PL- Consultation- Conservation response

AL/9/26/S73

Address: The Square House Hook Lane Aldingbourne PO20 3TS

Proposal: Variation of condition 2 imposed under AL/55/25/HH relating to plans condition.

BOOT ROOM DETAIL
NORTHWEST ELEVATION
scale 1_50

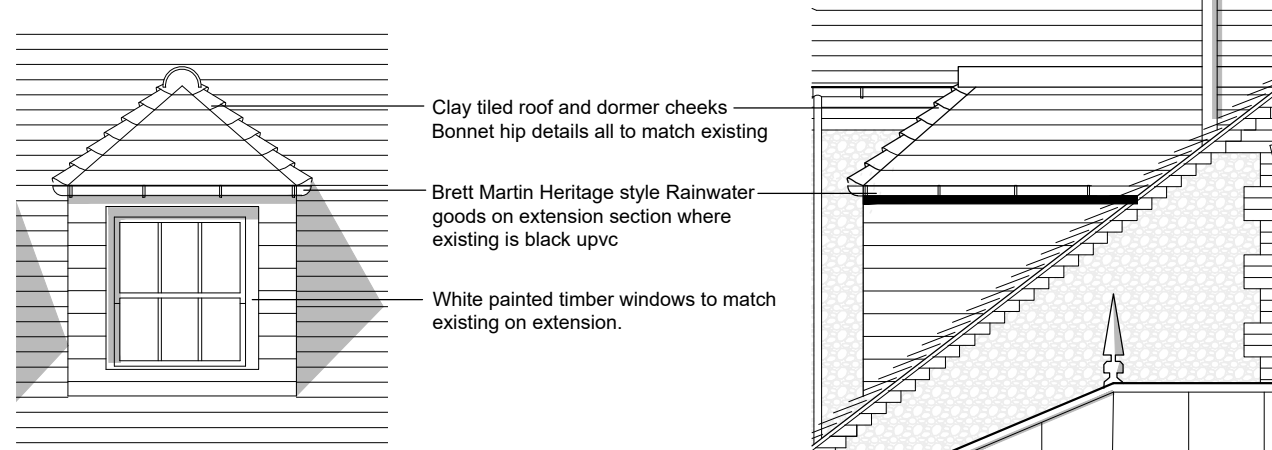
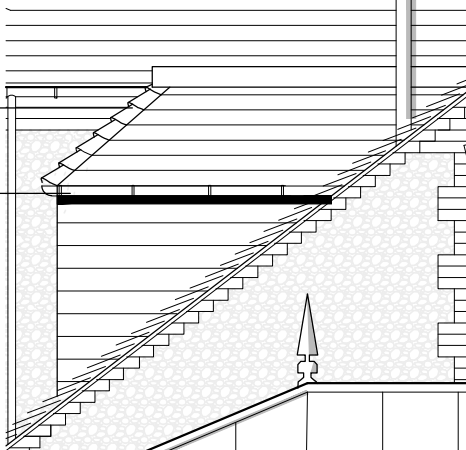
The proposal seeks to amend the window details to the proposed boot room. The windows will change from casements to sash windows, and the number has also been reduced by one. I note that we have already agreed a design for a new sash window as part of the current application, and assume that this design would be used in the new windows proposed here as well.

I believe that the revision to the windows is acceptable.
